From: Amanda Scholes on behalf of Planning.Responses
Sent: 28 January 2022 10:20
To: Planning Scanning
Subject: FW: 95888 Land at Northwood Farm Flexible Generator Plant and associated infrastructure CM/69/21/PL
Attachments: 3453_L_GA_0_01B_Landscape General Arrangement.pdf; 3453_L_Outline Plant Schedule.pdf; 3453_Bilsham_LVA - FV1.pdf; Appendix 2.pdf
Importance: High

From: Sue Howell <Sue.Howell@arun.gov.uk>
Sent: 20 January 2022 11:35
To: Anita Gardner <Anita.Gardner@arun.gov.uk>
Subject: FW: 95888 Land at Northwood Farm Flexible Generator Plant and associated infrastructure CM/69/21/PL
Importance: High

TITLE
LANDSCAPE_GENERAL_ARRANGEMENT & ELEVATION

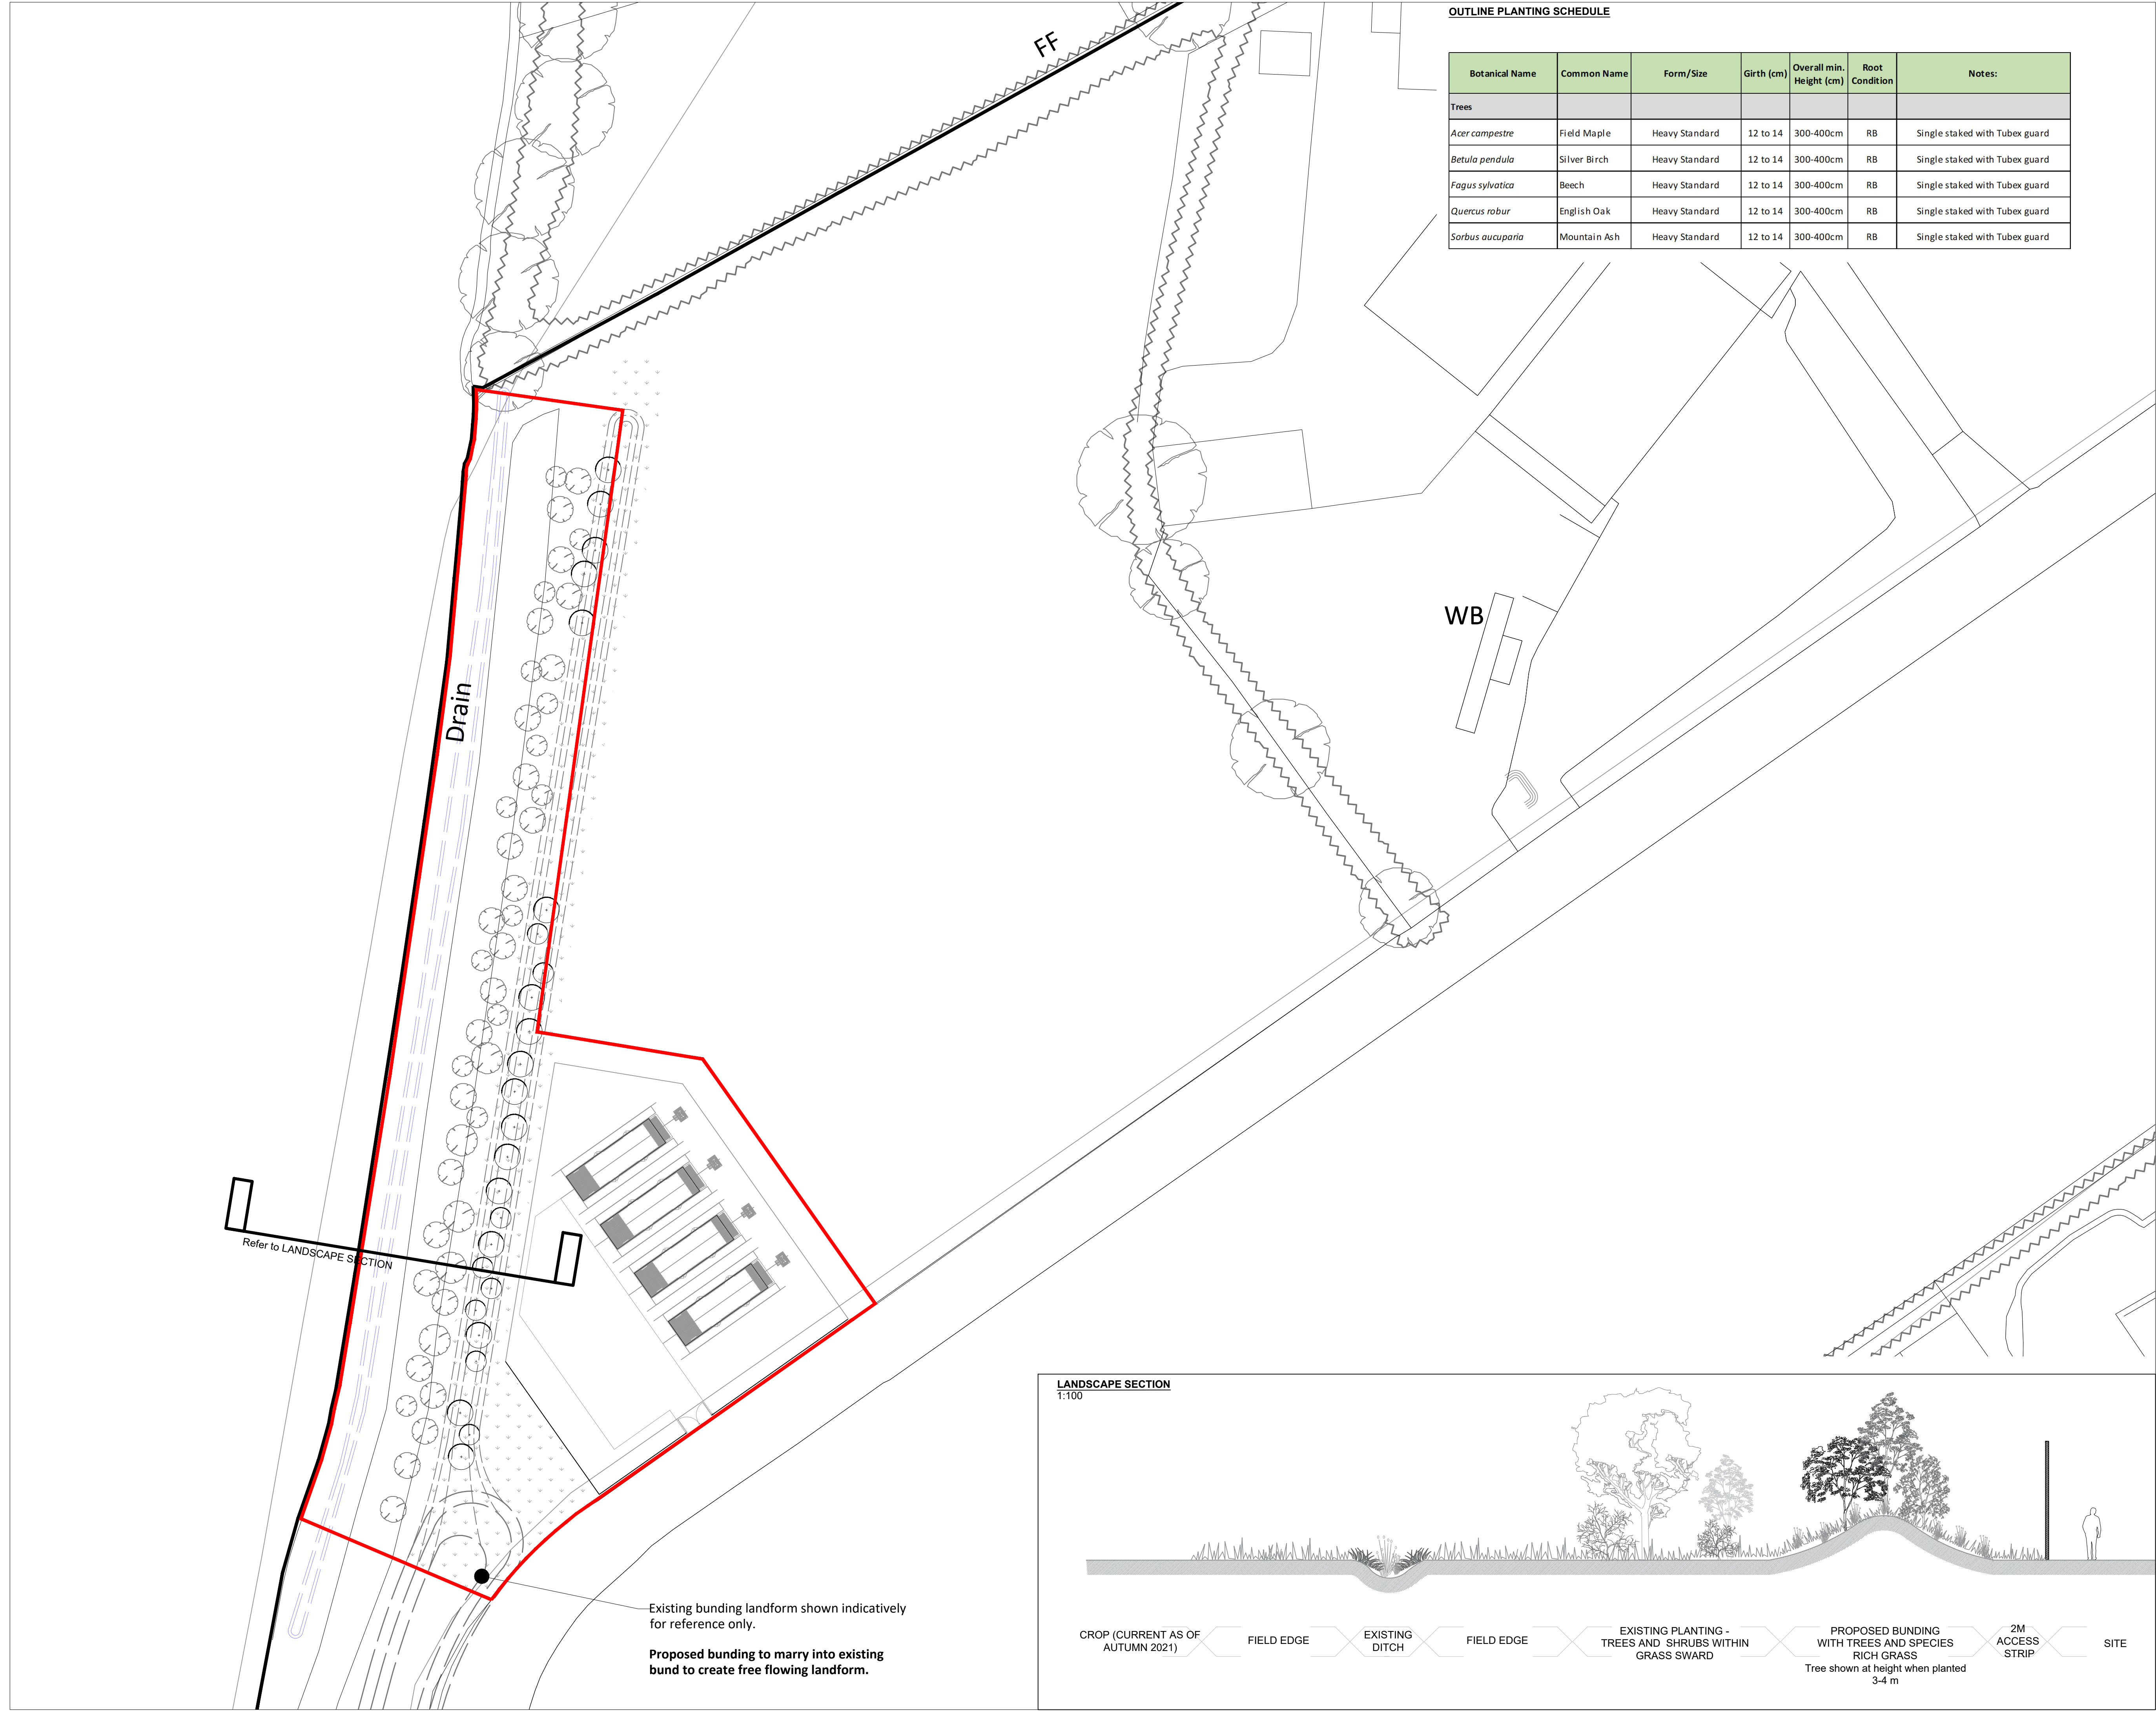
My last point would be specifically re the detail contained within the revised Landscape General Arrangement dwg. Further detail would need to be supplied re actual quantities of the heavy standard trees indicated for the embankment screening. It would also be prudent to have an element of smaller understory native planting incorporated into this area which would provide low level screening and would assist in the stabilisation of the embankment as the planting only of heavy standard specimens into made up ground has the potential to be problematic re-establishment and un-stabilising on the embankment structure.
